Crow Trees Farm, Crow Trees Brow, Chatburn, BB7 4AA
Section 96 Application – Non-Material Amendment pursuant to Planning Permission 3/2022/0966

On behalf of Pringle Homes, we submit a Non-Material Amendment Application in respect of the recent planning permission for residential development on land to the rear of Crow Trees Farm, Chatburn.

CLIENT	Pringle Homes			
PROJECT	Proposed Residential Development at Crow Trees Farm, Crow Trees Brow, Chatburn, Clitheroe, Lancashire, BB7 4AA			
DRAWING	The Bristow (Apartment Block) - Proposed Floor Plans & Elevations			
DRAWN	JD	DATE	18/12/24	NUMBER   21/139/HT04
SCALE	1:100	SHEET	A3	REVISION   -

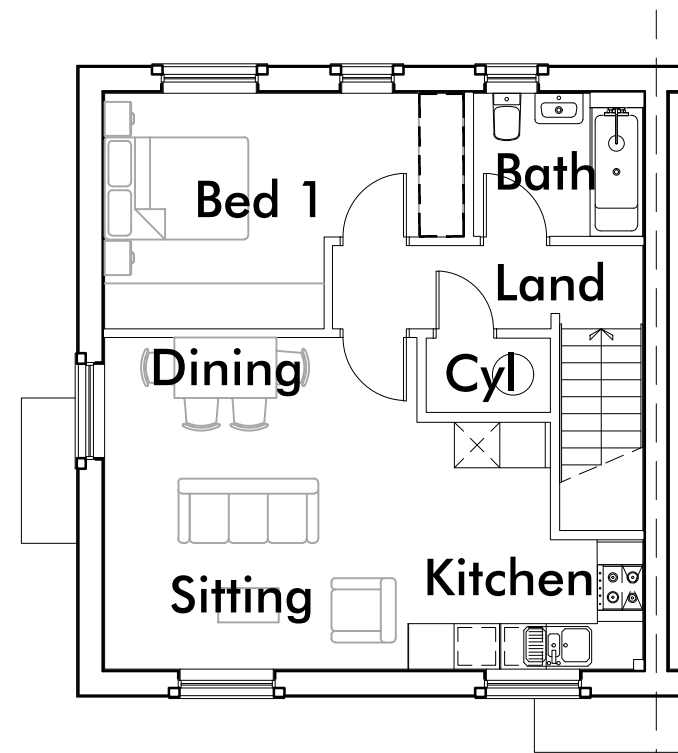
Externally the minor changes are; to the Hastings, bedroom 2 window repositioned 337.5mm left; to the Raleigh, bedroom 3 window repositioned 225mm right; to the Bristow, lounge window repositioned 225mm higher; to the Bransfield, bathroom window repositioned 112.5mm to the right.
